Laurie Leader - FW: BP#2014-02014 16 Guilford Ct - Plan review comments

From: "Laurie Leader" <LRL@portlandmaine.gov>
Date: September 18, 2014 at 3:04:54 PM EDT
To: <phishman@maine.rr.com>
Subject: BP#2014-02014 16 Guilford Ct - Plan review comments

1 ENLARGED BATH PLAN
SCALE: 1/2" = 1'-0"

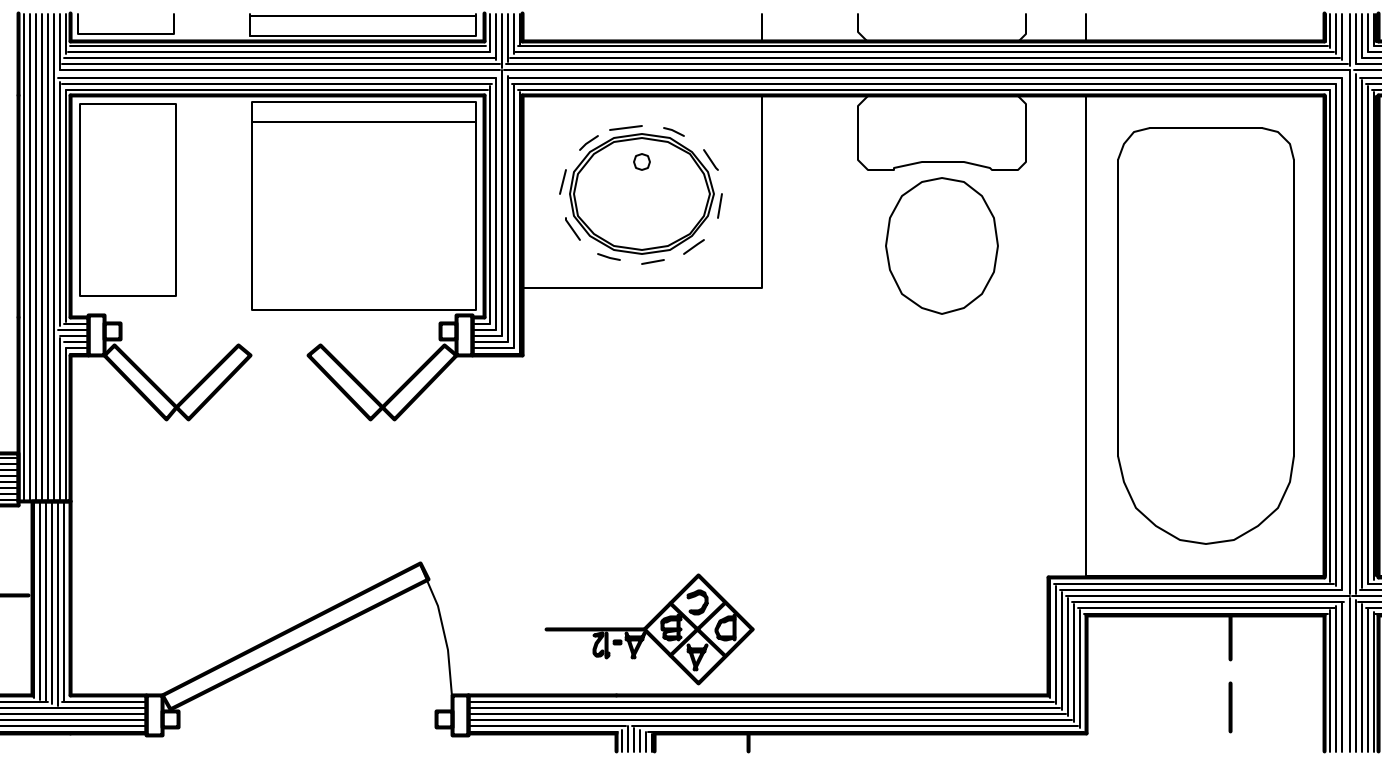
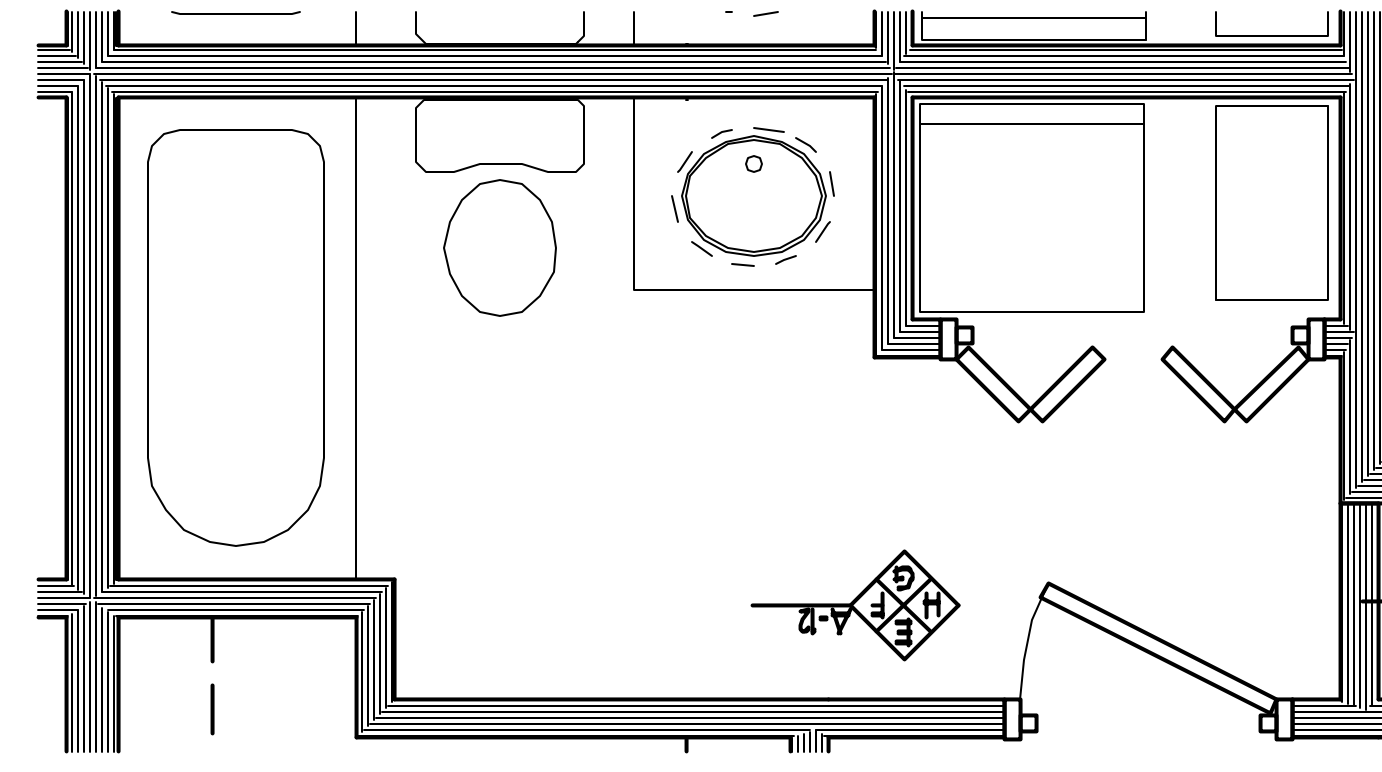
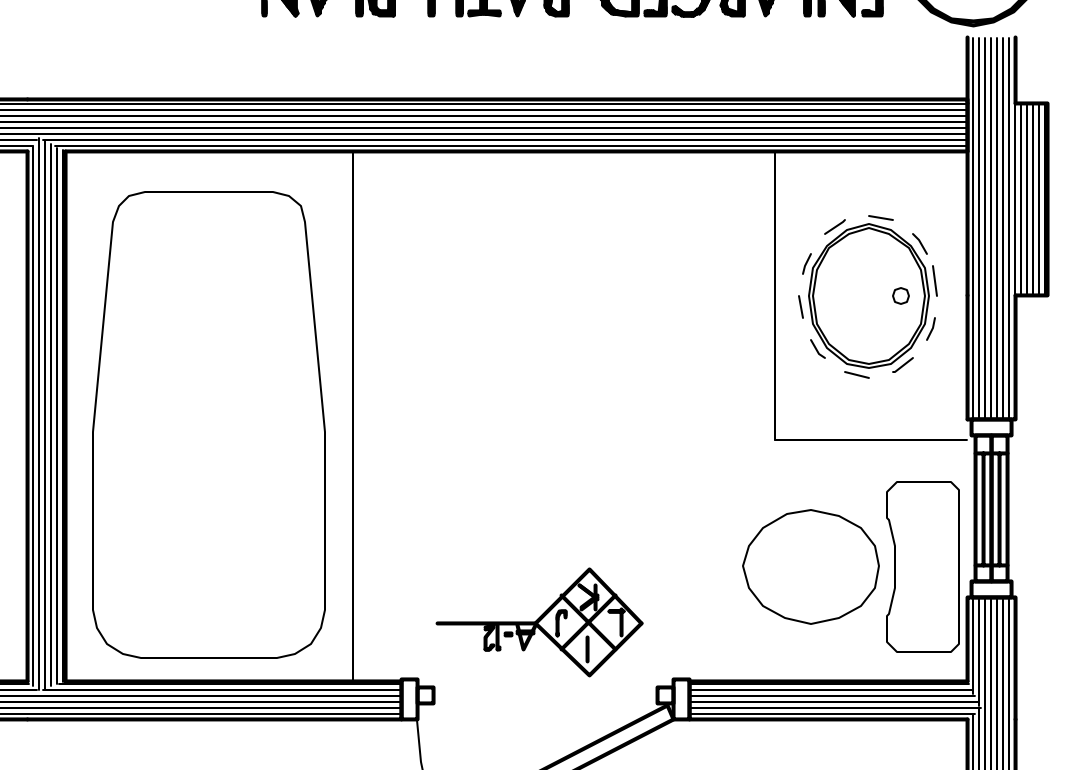
1. Is the door in the basement office a direct exit to the exterior at ground level? Or is this below grade?
2. Clarify the floor to ceiling height in the office.
3. Provide clearances of bathroom fixtures per the UPC Section 407.5.

1. The door is definitely a direct exit and will remain as such. It is at ground level. I can provide a photo if you need.
2. Ceiling is 7' 6"
3. I have attached a drawing indicating clearances of bathroom fixtures.
